Planning Report

Application Number: 22/00017/RES

Application Site: 3 Ceres Crescent, Epsom, Surrey, KT17 1FF

Proposal: Retrospective application for the Variation of Condition 2 (Approved Plans) of planning permission 21/00629/FLH to increase the roof height of the approved single storey rear extension from 2.83m to 3m.

DWG TITLE  
**PROPOSED FRONT & REAR ELEVATIONS**

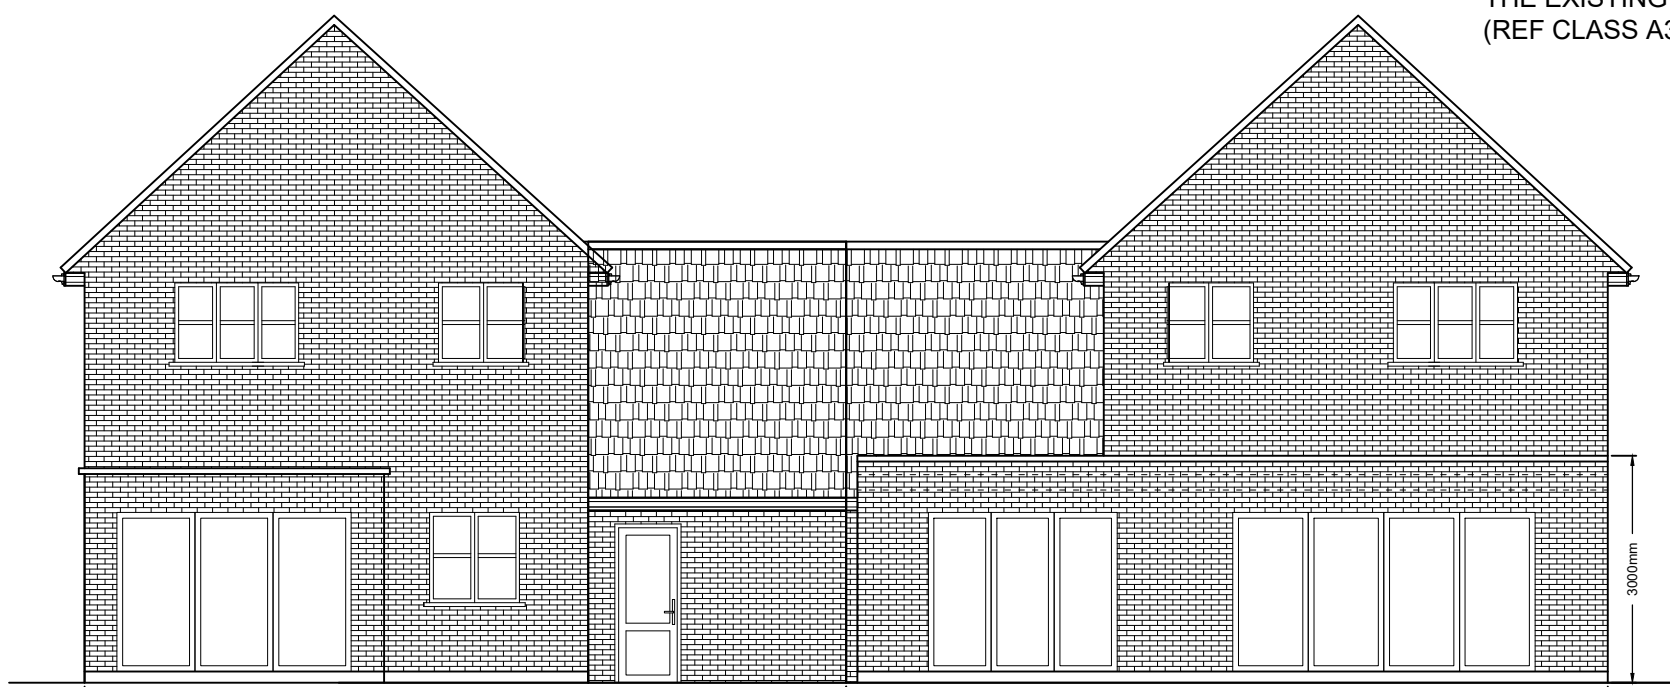
1. The impact of the proposal on the character and appearance of the host dwelling and wider character of the area has been fully assessed under planning application 21/00629/FLH and found to be acceptable and policy compliant.
2. The current proposal involves raising the overall height of the approved single storey rear extension from 2.83m to 3m.
3. This is considered to be a relatively modest increase in height which would not change the overall appearance of the approved extension and would therefore not result in harm to the character of the host dwelling and the wider character of the area.

5. The impact of the proposal on the amenities of the neighbouring properties has been fully assessed under planning application 21/00629/FLH and found to be acceptable and policy compliant.
6. Whilst the height of the approved extension would be increased by 17cms, it will still comply with the BRE 45-degree site line tests taken from the nearest rear habitable window at the immediately adjoining properties. As such it is not considered that the proposal would result in undue loss of light, overshadowing or overbearing impact.
7. In light of the above, the proposal is considered to comply with Policy DM10 of the Development Management Policies Document 2015, the Council's Household Applications SPG 2004 and the NPPF 2021.

Recommendation: Grant, subject to Planning Conditions
